ENG-SF21026-R3-FDR.pdf Markup Summary

NORTH POND NORTH FOREBAY
SCALE: 1"=10'

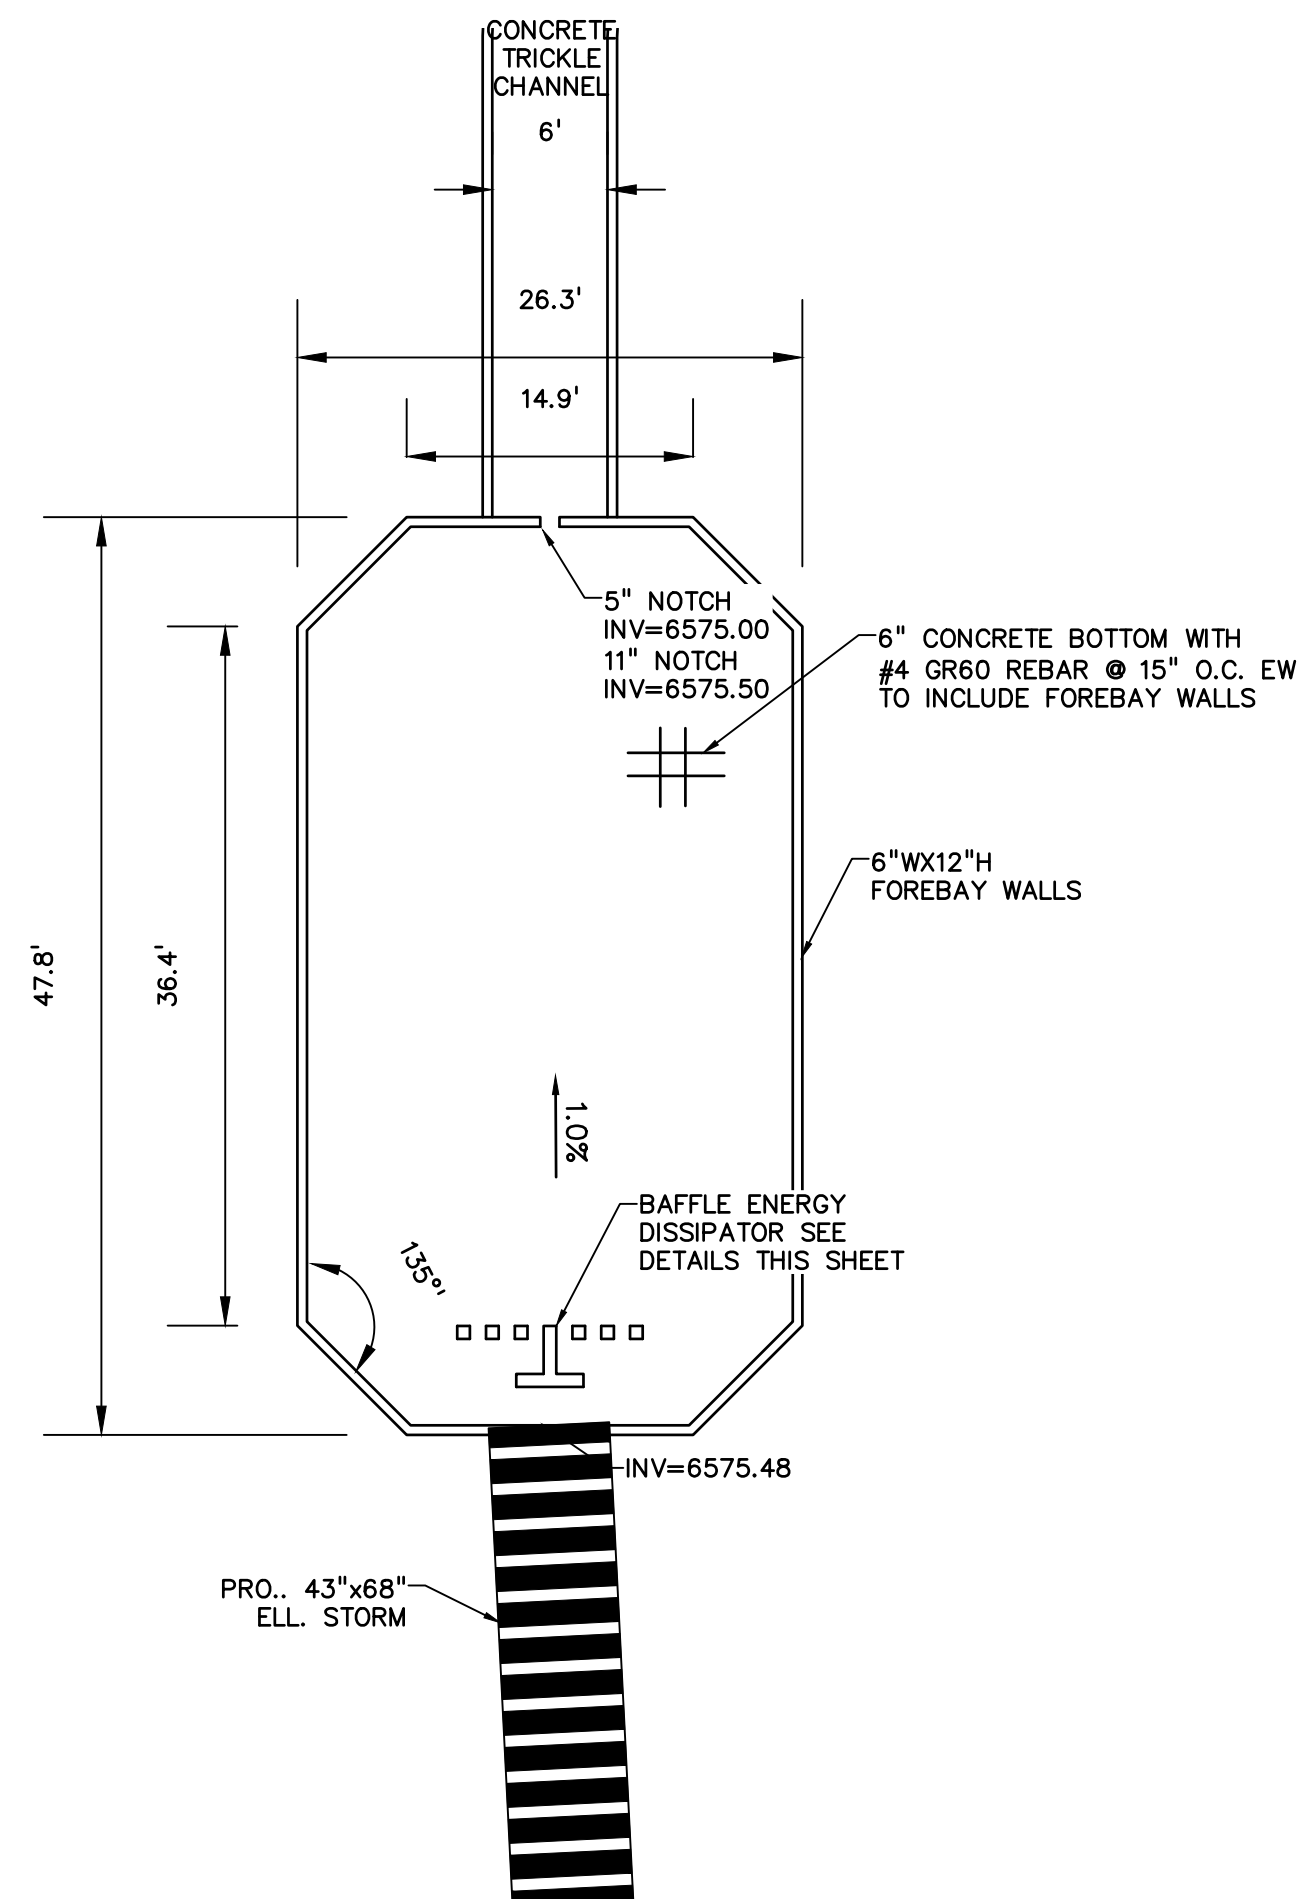
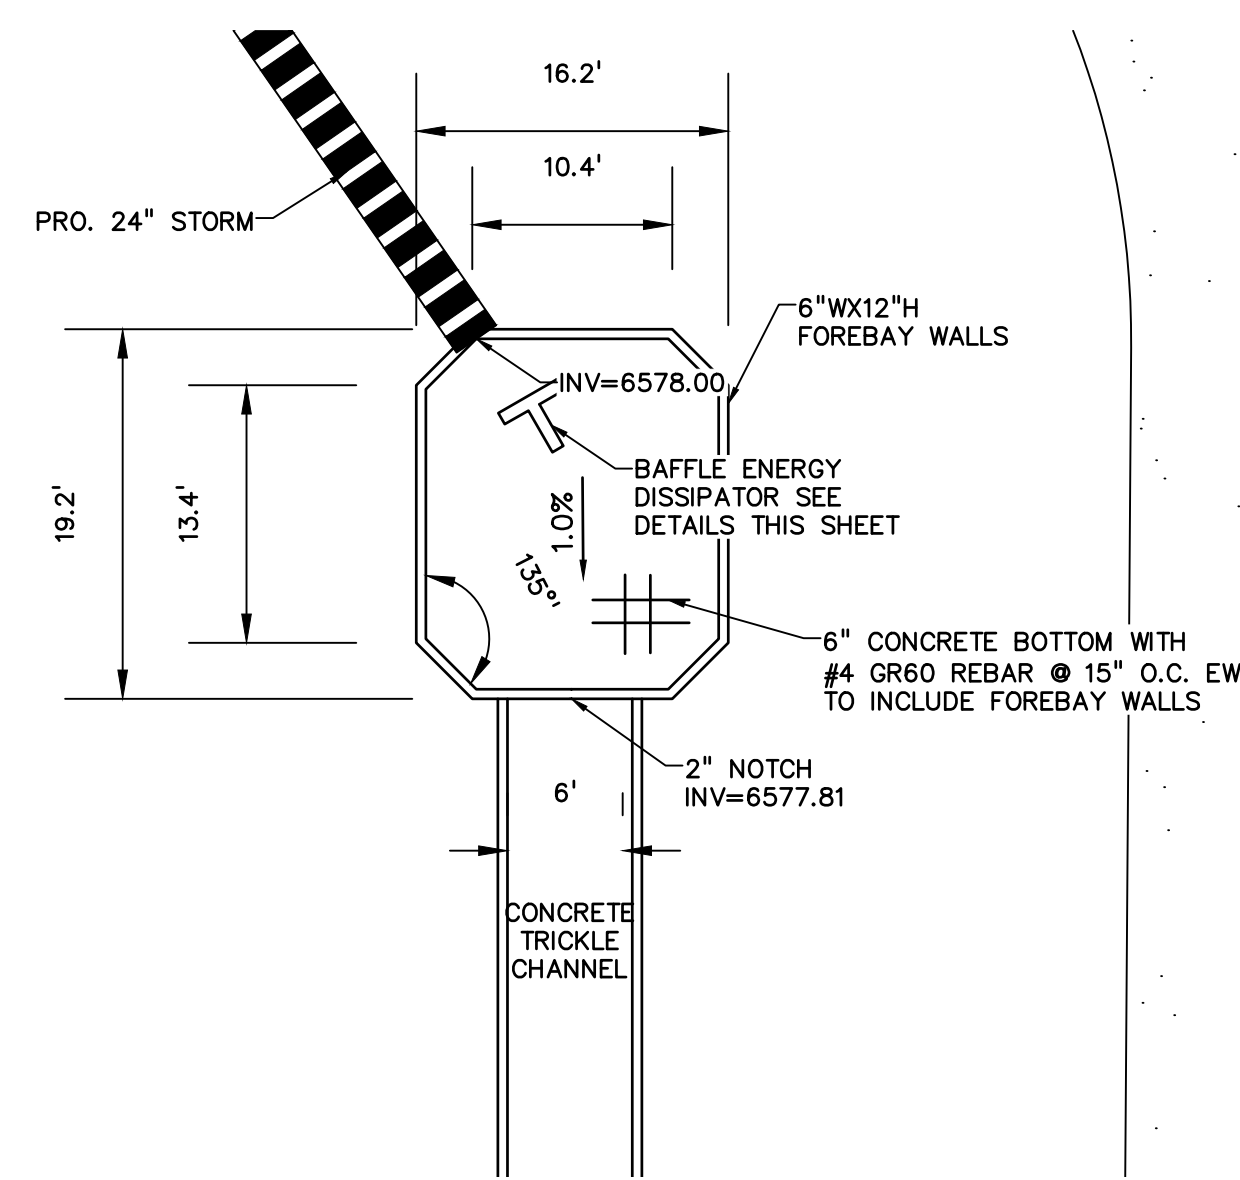
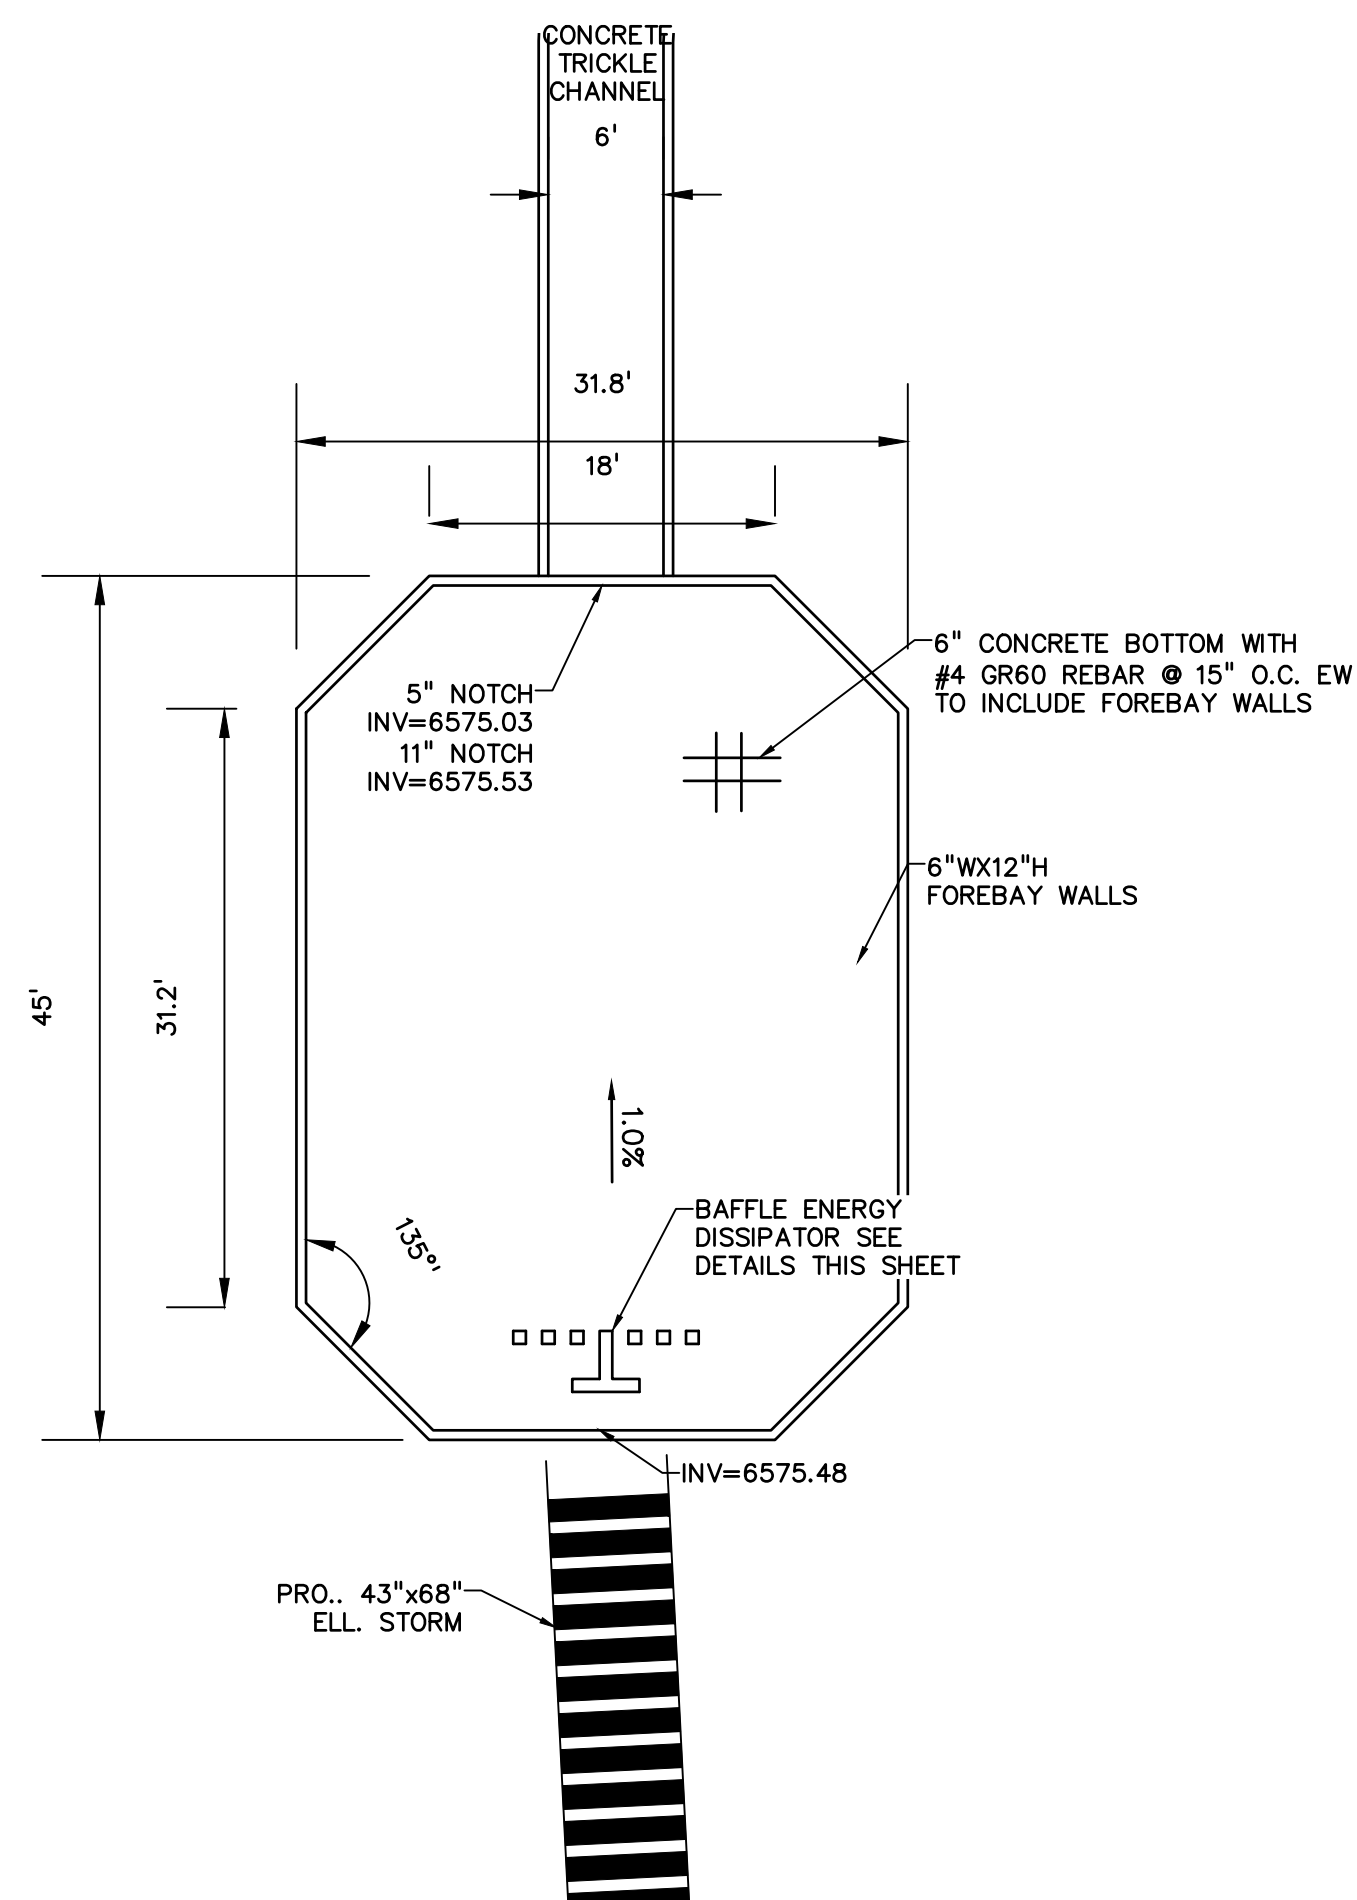
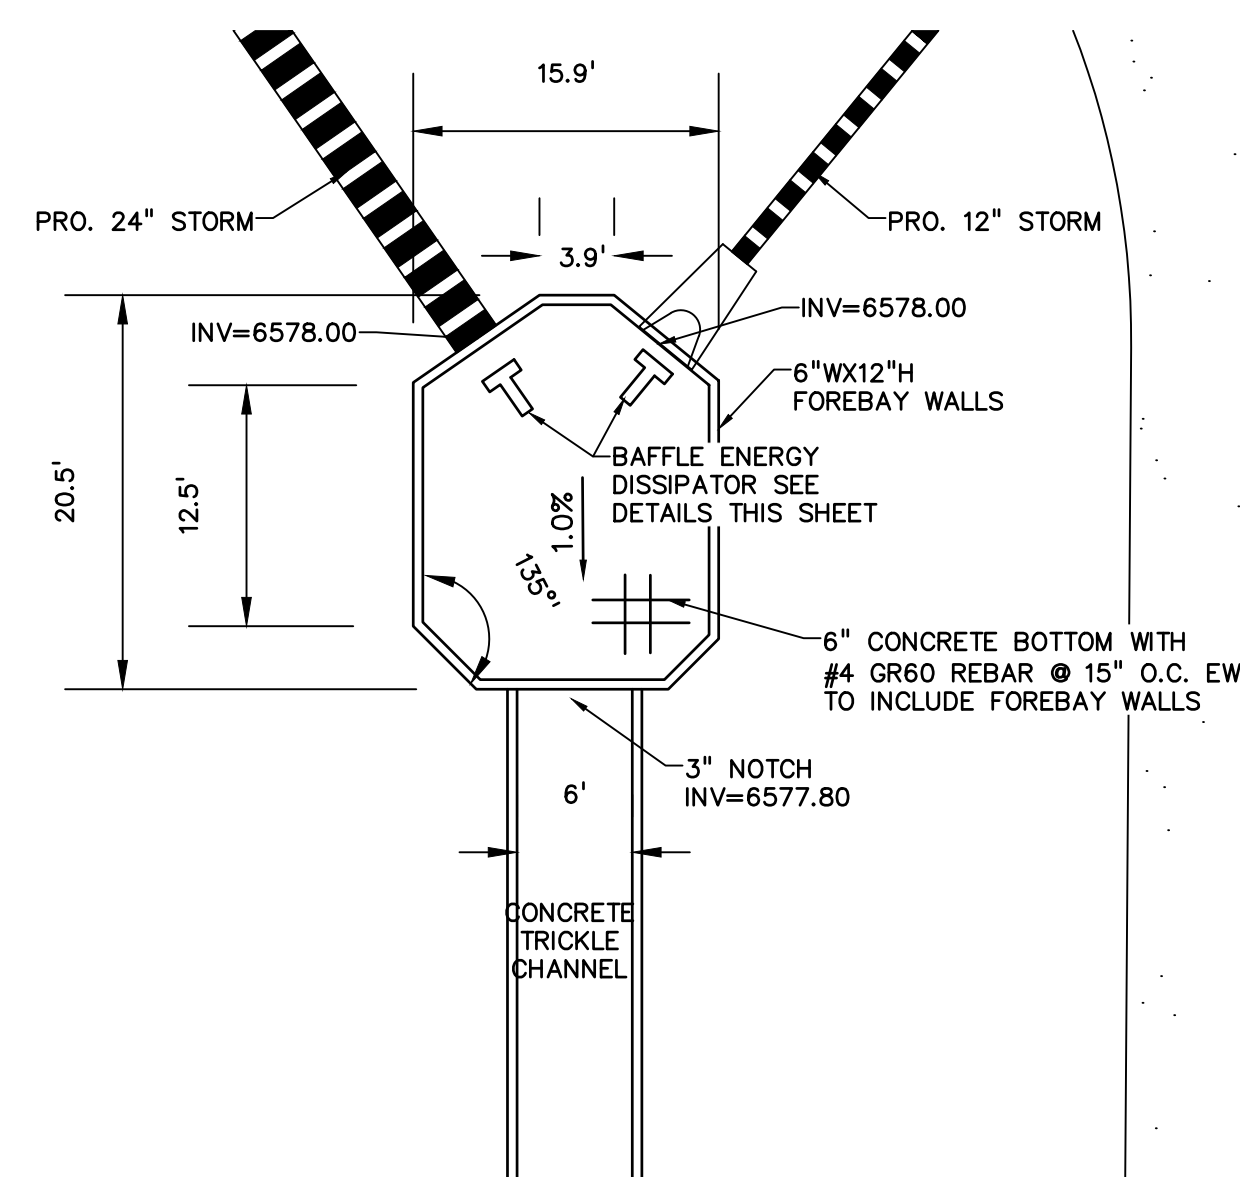
Each forebay should be designed per area directed to it.

WQCV calculated for each tributary area and volume confirmed as adequate
